**Memorandum
 Planning and Urban Development Department
 Planning Division**

To: Stuart O’Brien, Chair and Members of the Portland Planning Board
 From: Jean Fraser, Planner
 Date: May 15th, 2015
 Re: Neighborhood Center and Preschool/Daycare
 1342 Congress Street
 Site Plan and Conditional Use(s)
 Jewish Community Alliance of Southern Maine, Applicant
 Project #: 2015-058 CBL: 191 B016001
 Meeting Date: May 19th, 2015

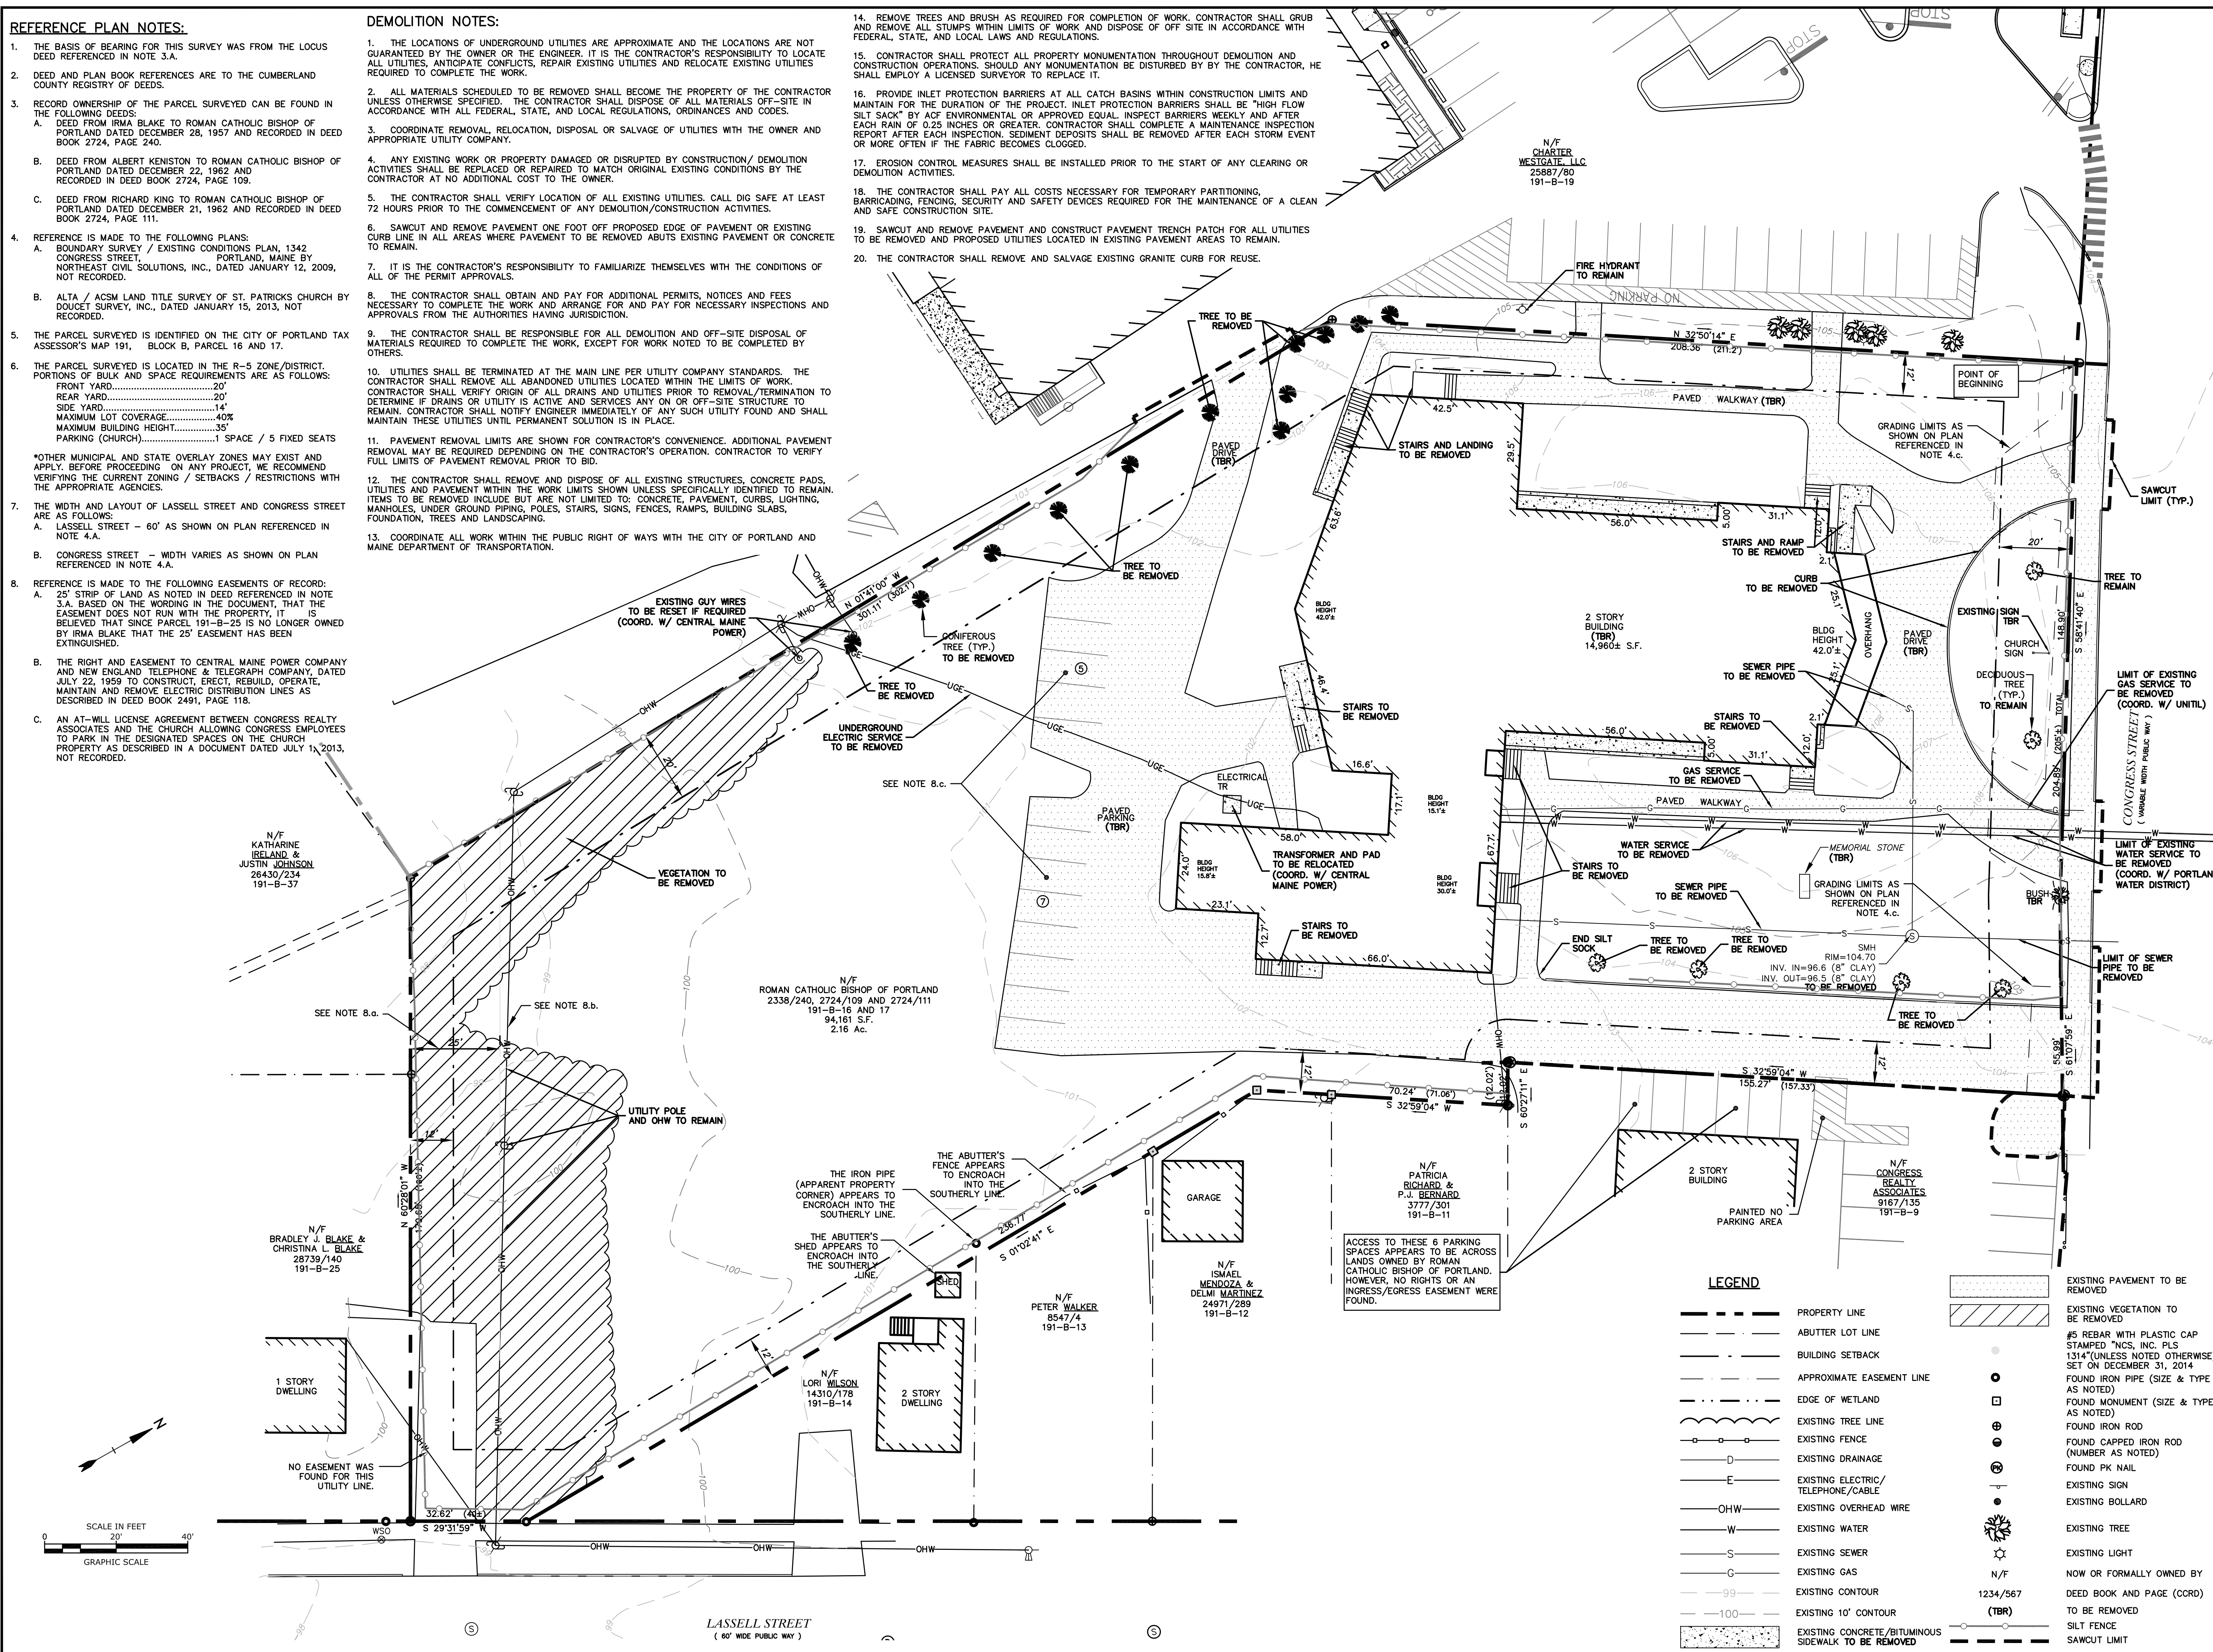
The Demolition Plan in Plan P2 shows the proposed removal of the 5 trees alongside the drive by the dental offices, and a considerable area of vegetation around the back of the site is also removed including near Lassall Street. A further 12 conifer trees are removed along the west boundary, which will become snow storage and parking area. The Landscape Plan in Plan P10 includes some replacement planting.

SITE PLAN

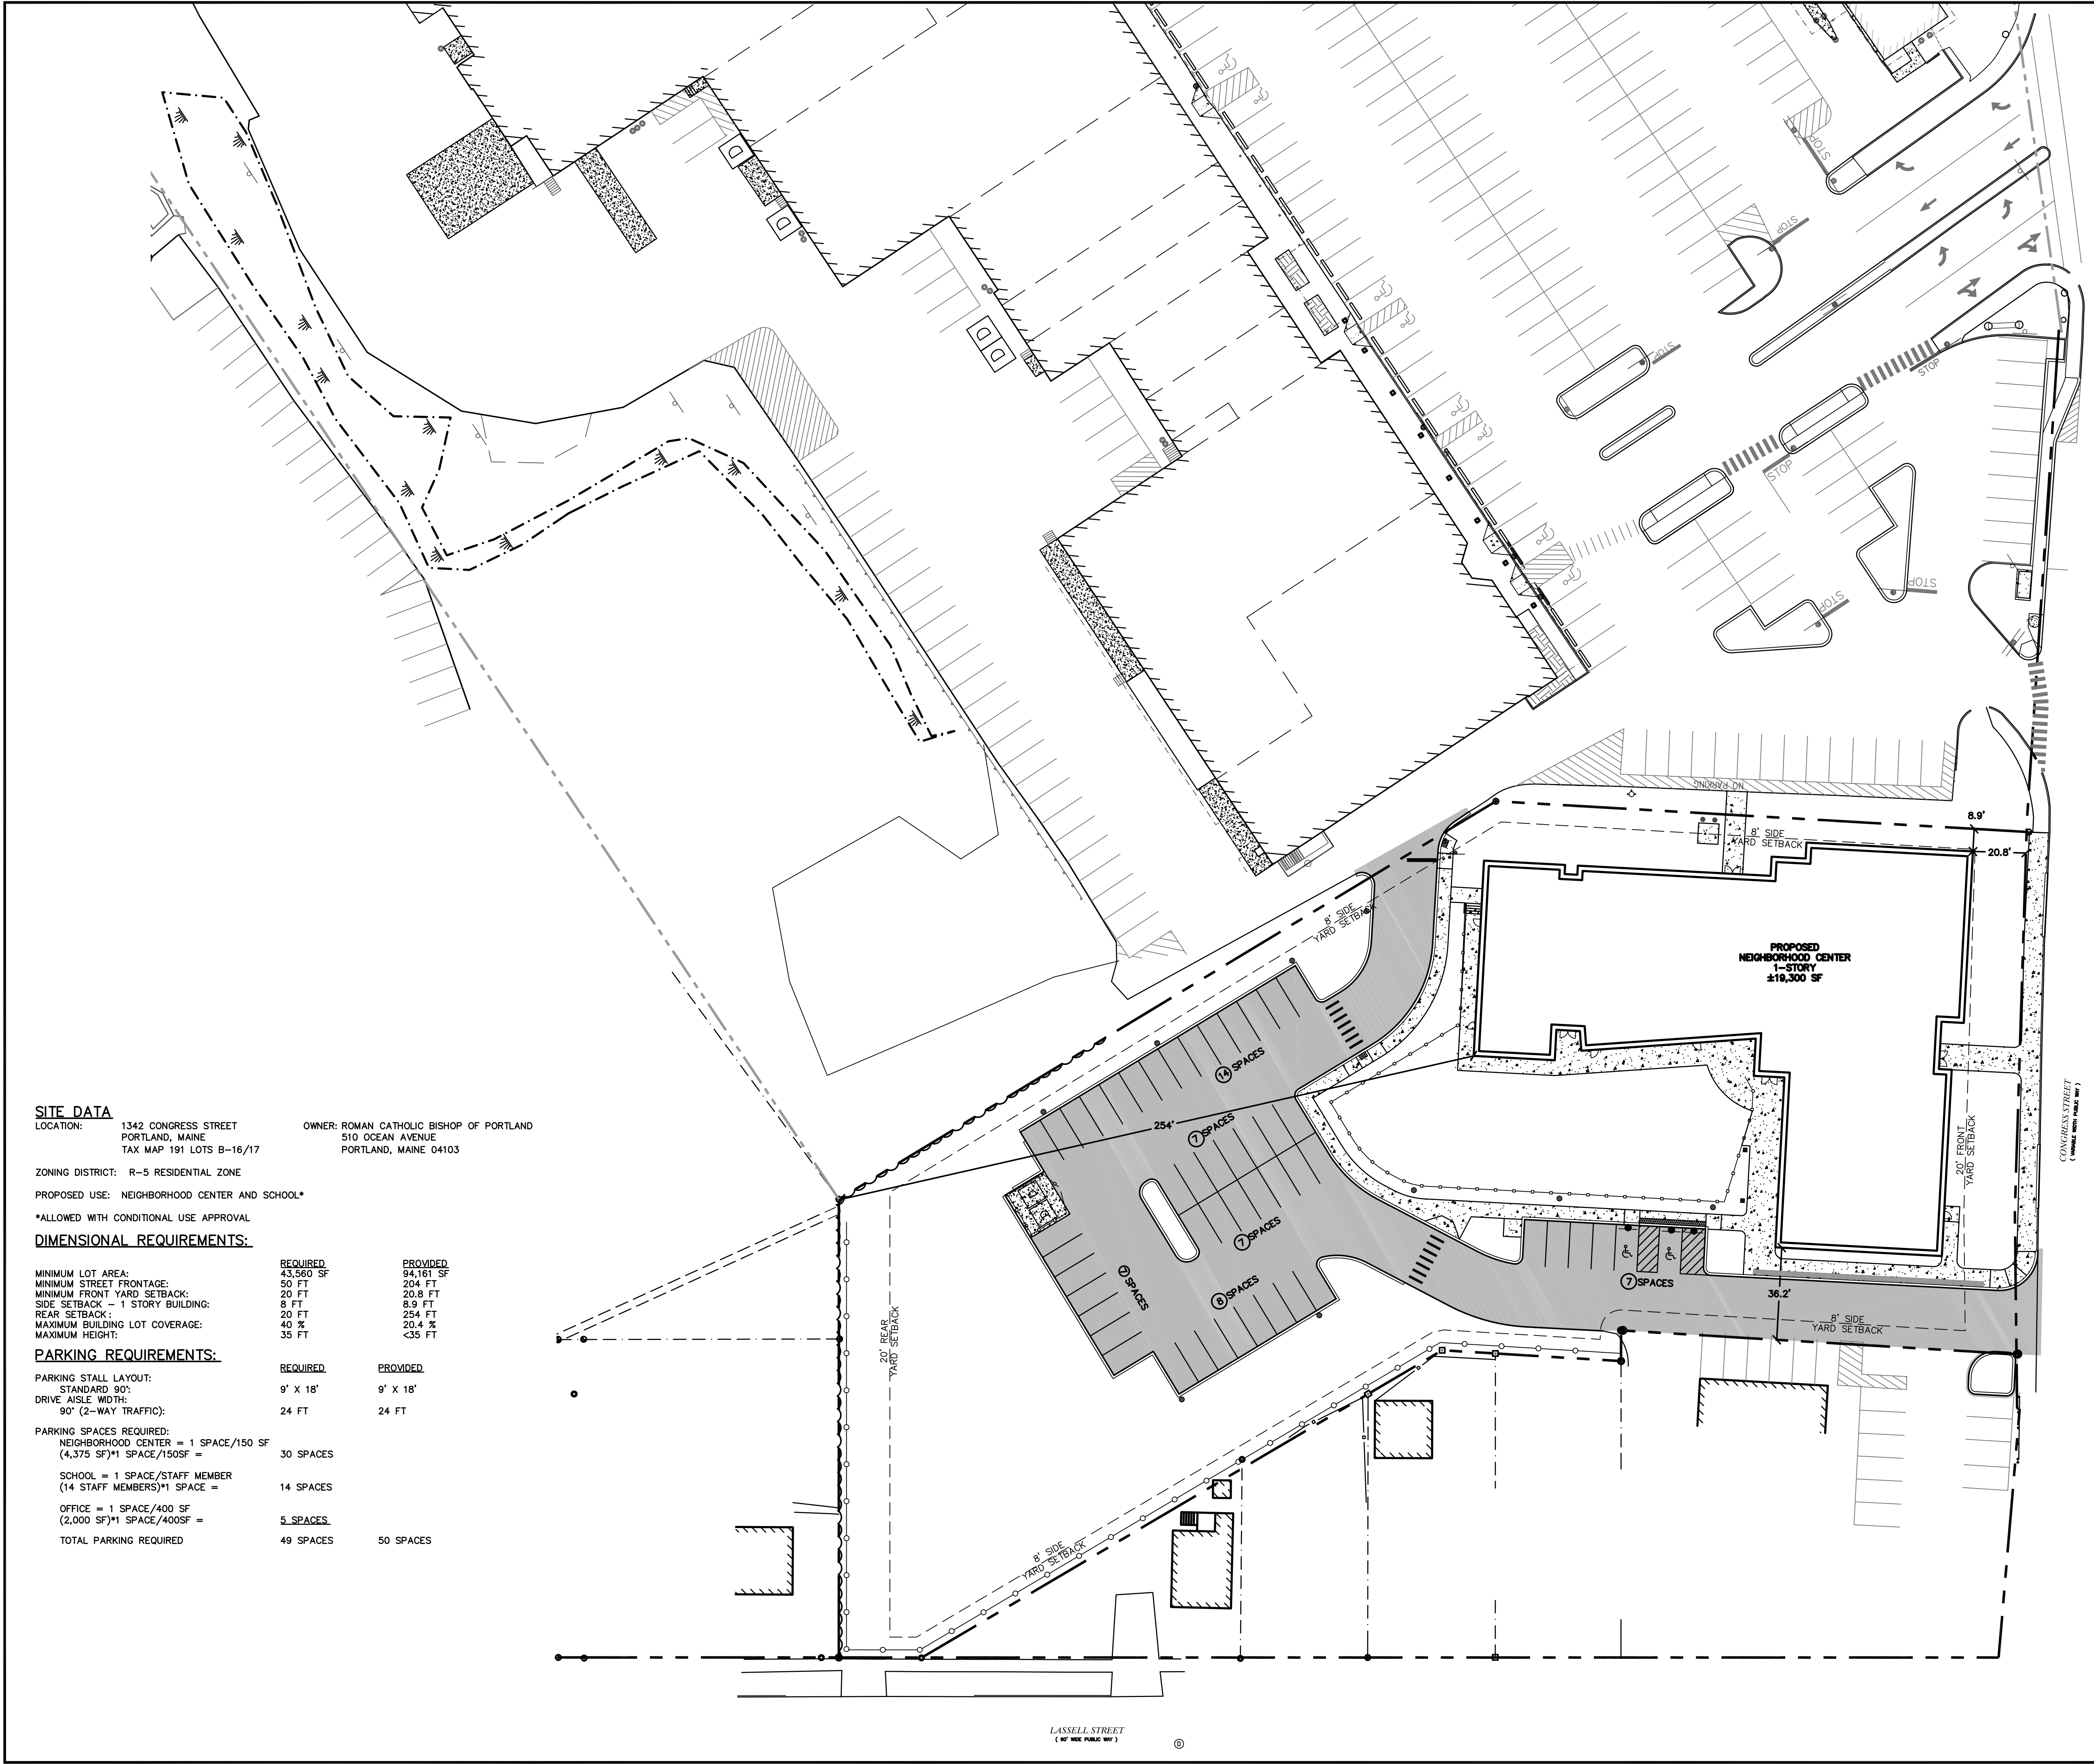
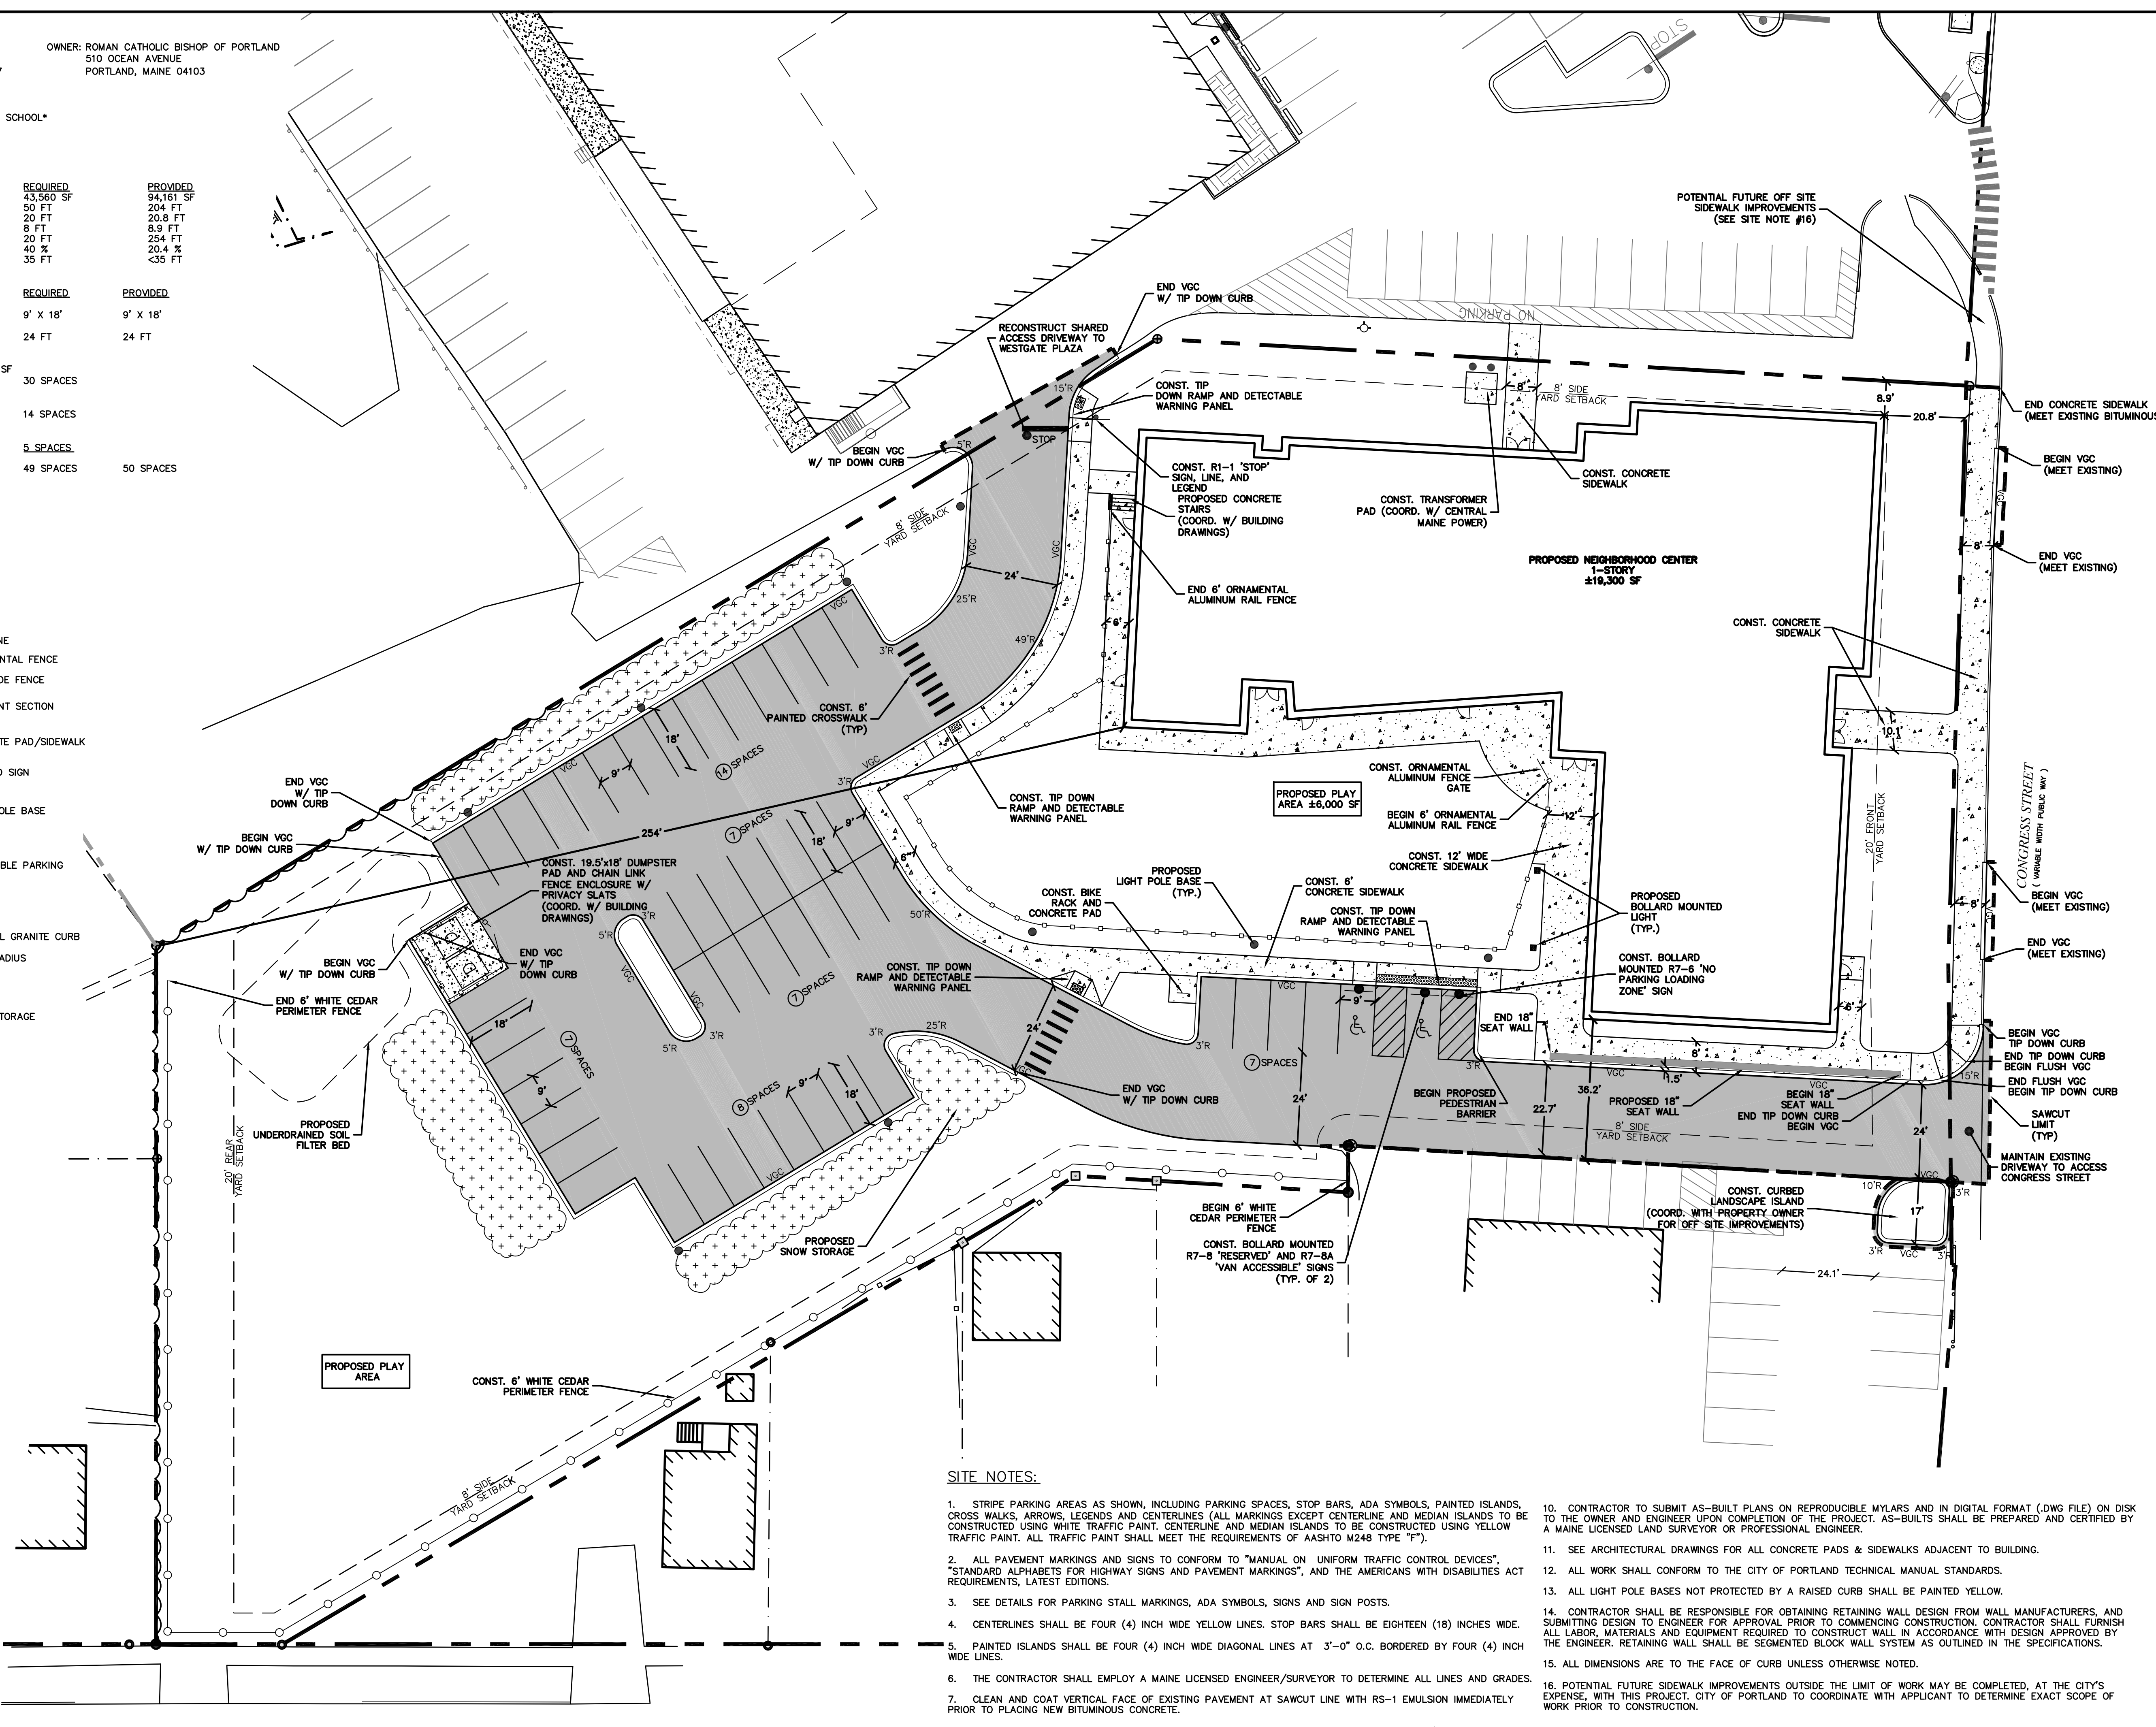
Parking: The Site Plan (Plan P4) shows 49 spaces on the plan, but the zoning assessment on that plan (in the notes) state that 50 spaces have been provided.
